KIRKLEES METROPOLITAN COUNCIL INVESTMENT & REGENERATION SERVICE

DELEGATED DECISION TO DETERMINE PLANNING APPLICATIONS

Reference No:	2025/62/92730/W
Site Address:	9, Regent Road, Kirkheaton, Huddersfield, HD5 0LW
Description:	Erection of extension to extend accommodation in first floor and basement
Recommending Officer:	Jennifer Booth

DRAWING TITLE
 EXISTING AND PROPOSED BLOCK
 PLANS

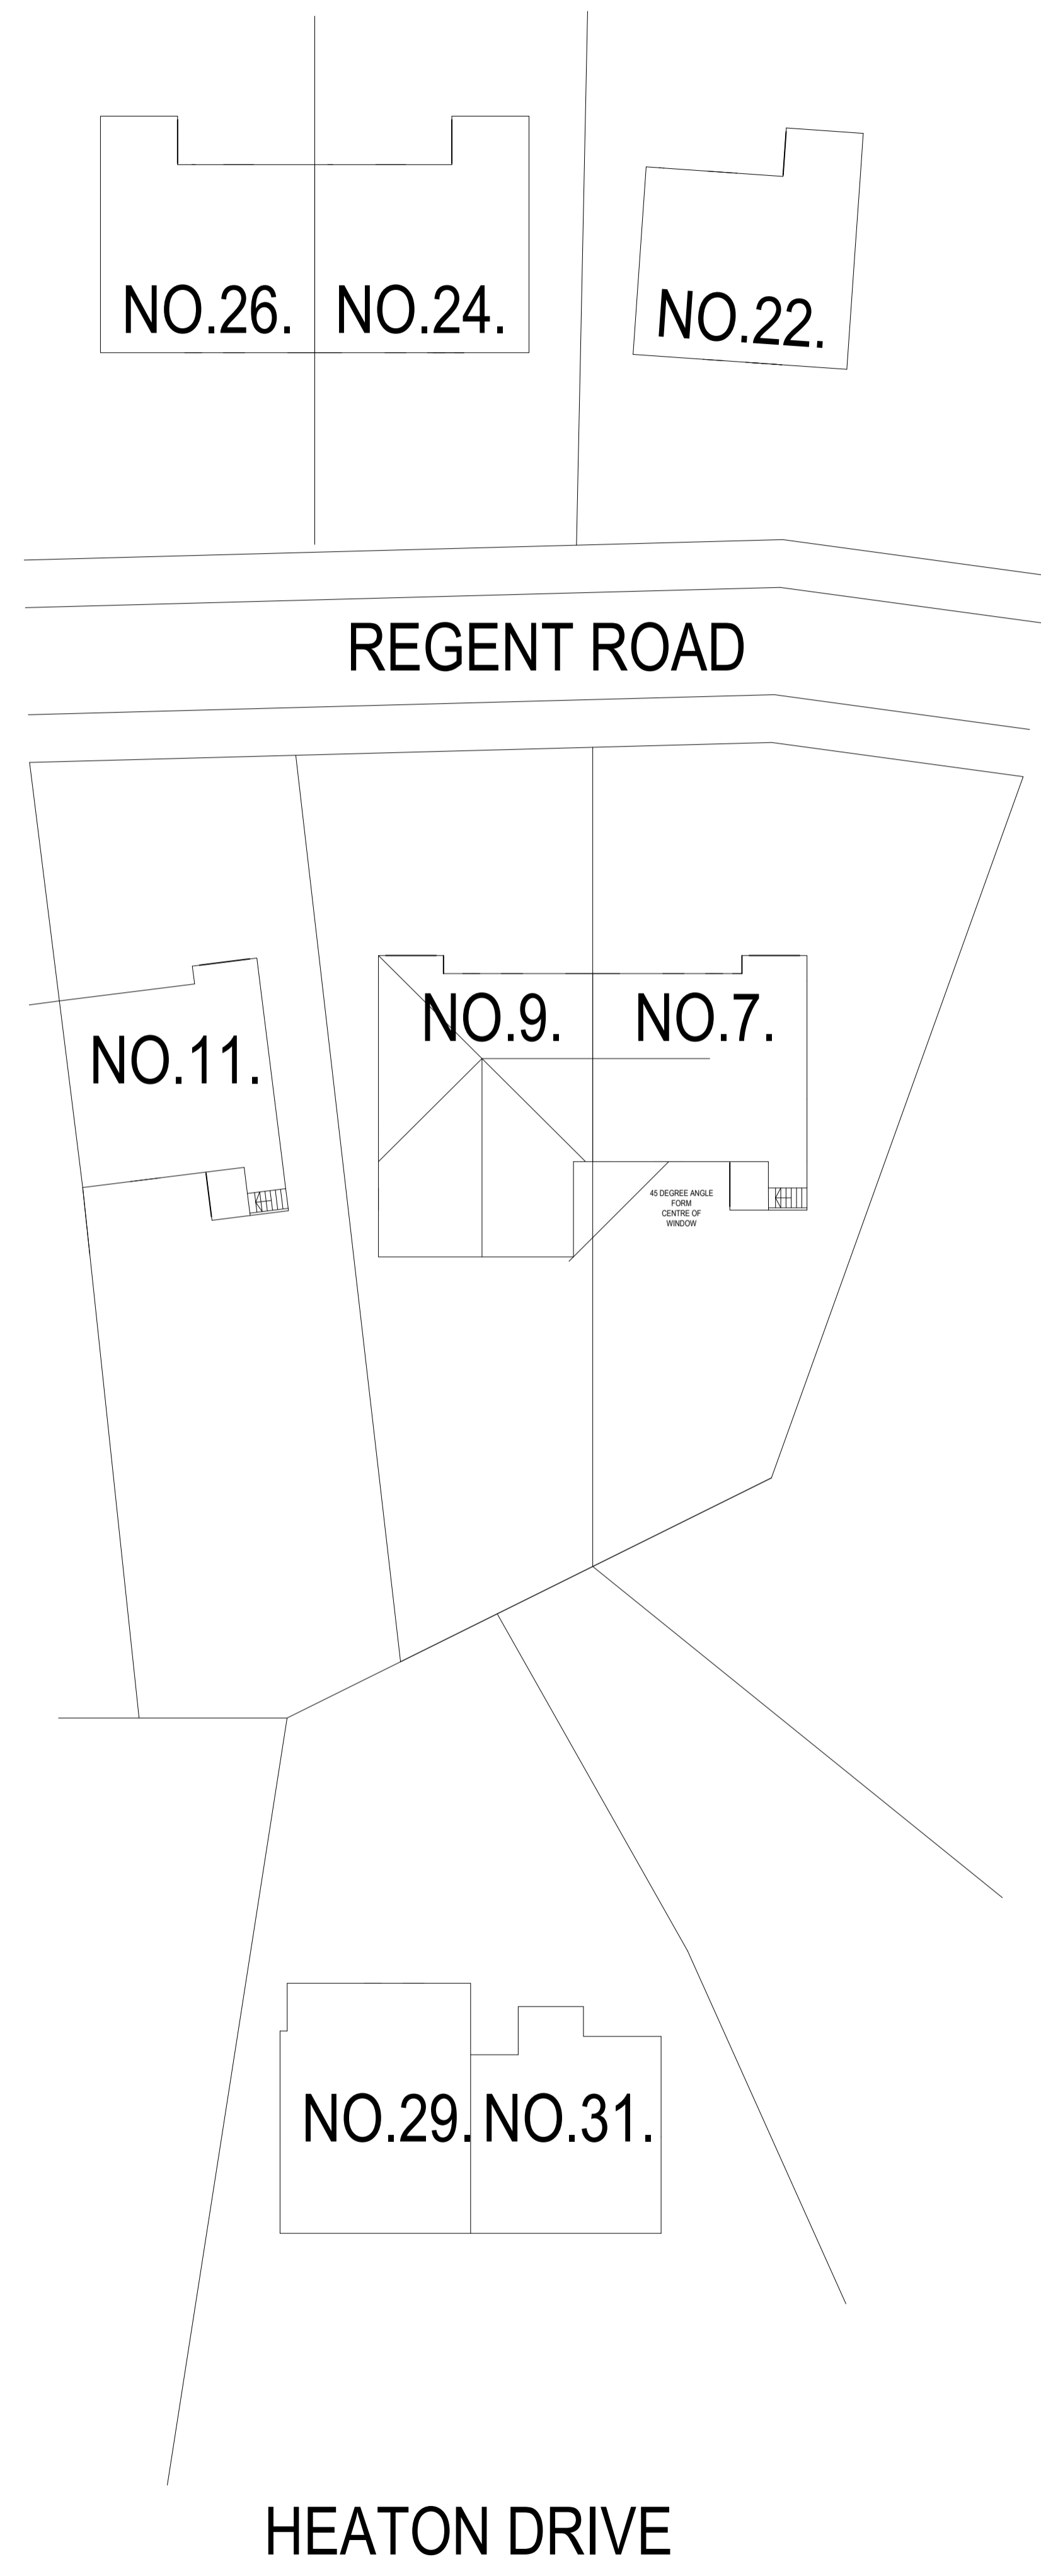
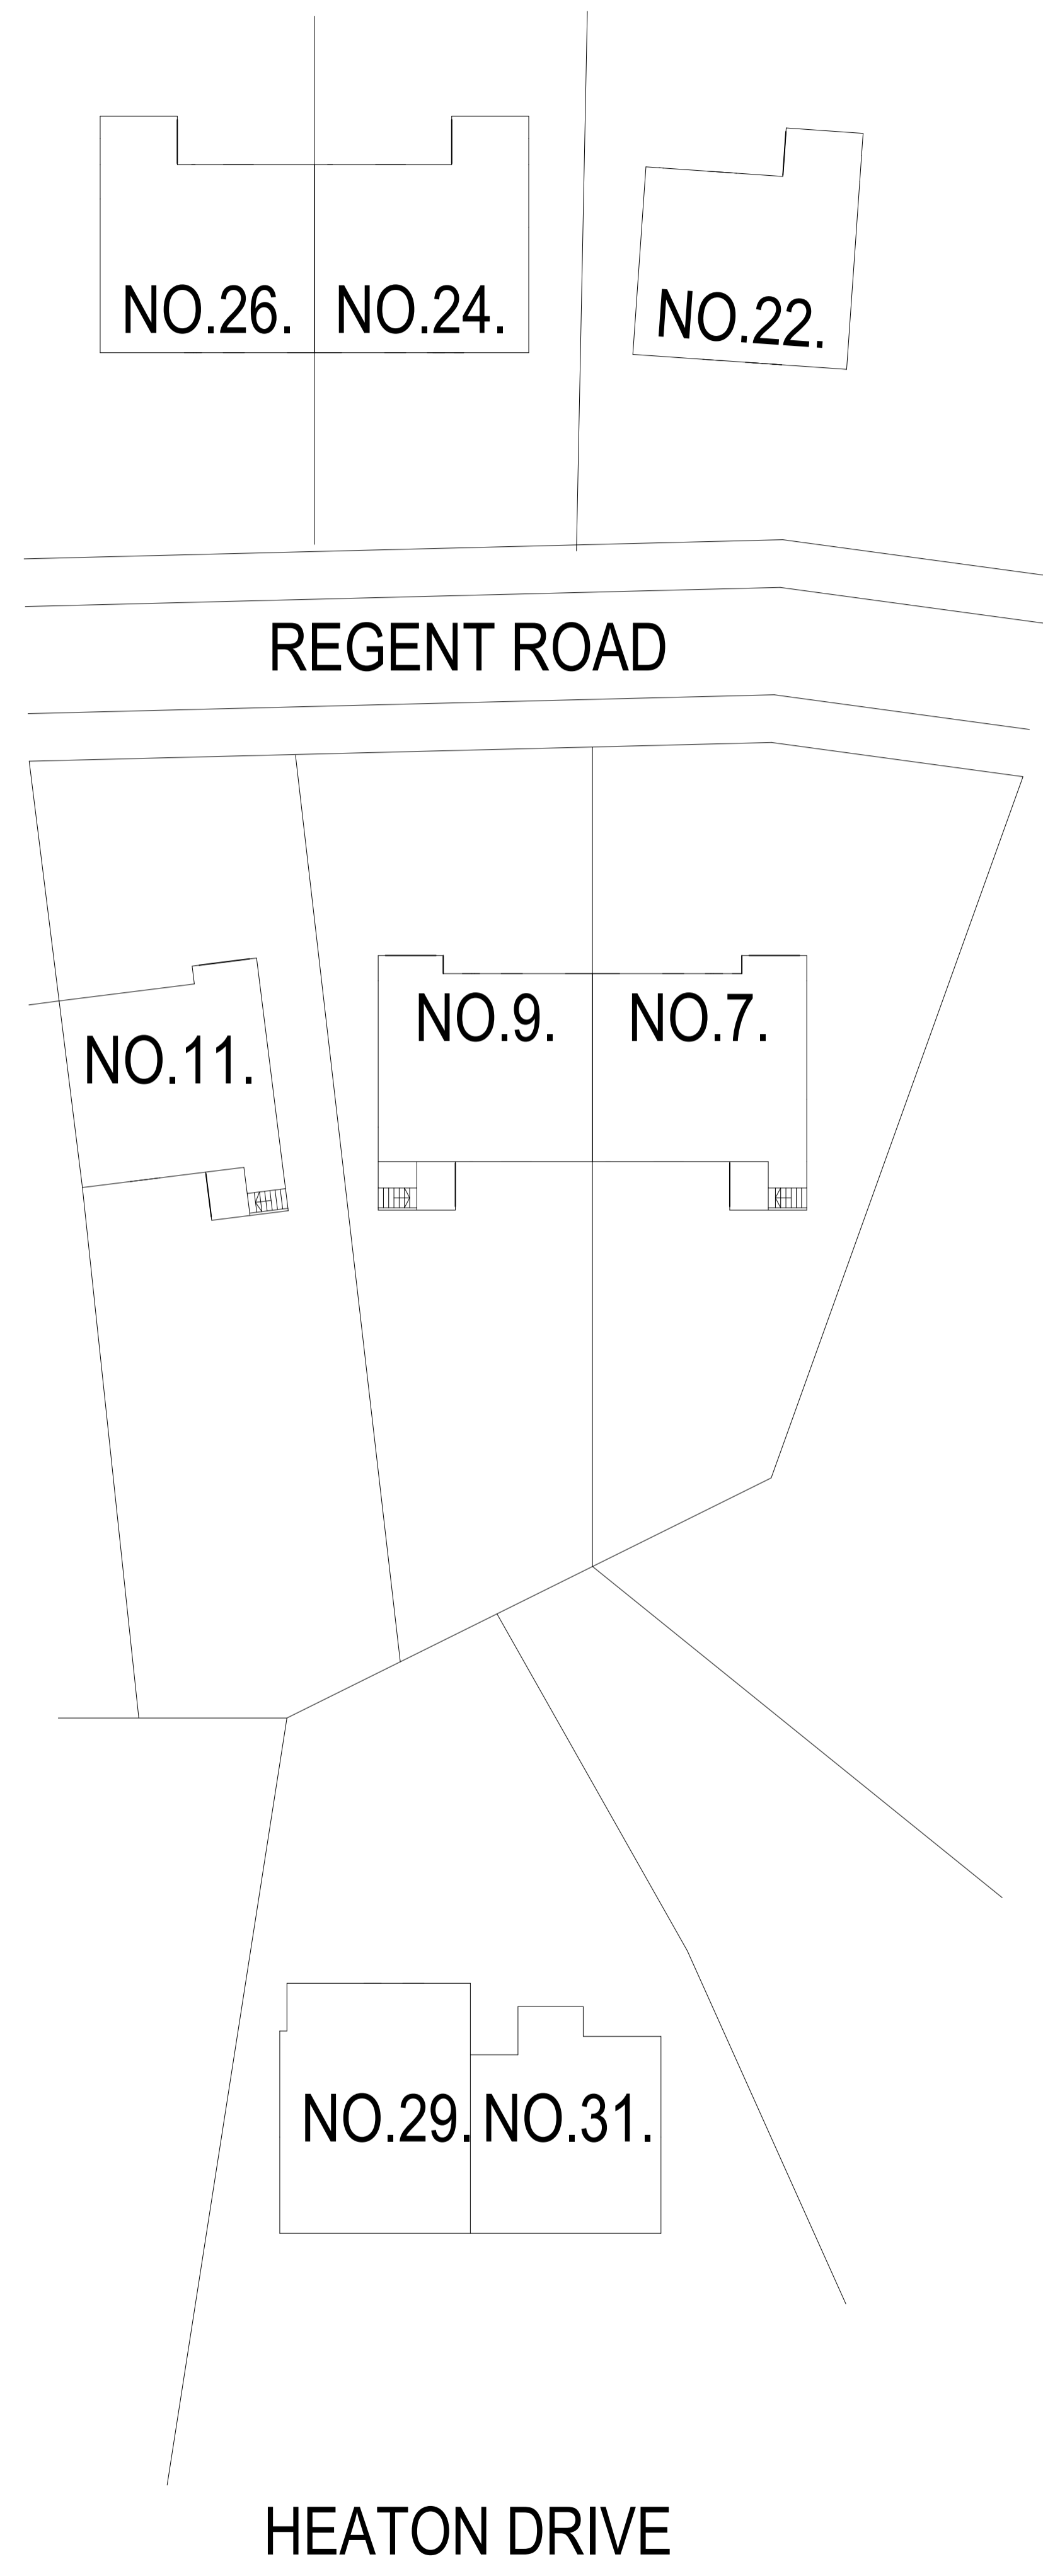
The adjoining property is located to the east of the application site. The proposed extension would be set slightly inset from the shared boundary, reducing its perceived massing and impact. The agent has provided a plan demonstrating compliance with the 45-degree guideline, with the line just glancing past the corner of the proposed extension. There would be no windows in the side elevation, and the glazing in the rear elevation would primarily overlook the applicant's own garden, with only limited oblique views across the neighbour's rear garden. This relationship indicates that the development would not result in an unacceptable loss of light, outlook, or privacy for the adjoining property, and the impact on residential amenity is considered to be within acceptable limits.

have been provided which reduced the projection, corrected the discrepancy and showed the 45 degree relationship with the adjoining dwelling. The alterations did not increase the scheme; therefore the amended plans have not been advertised.
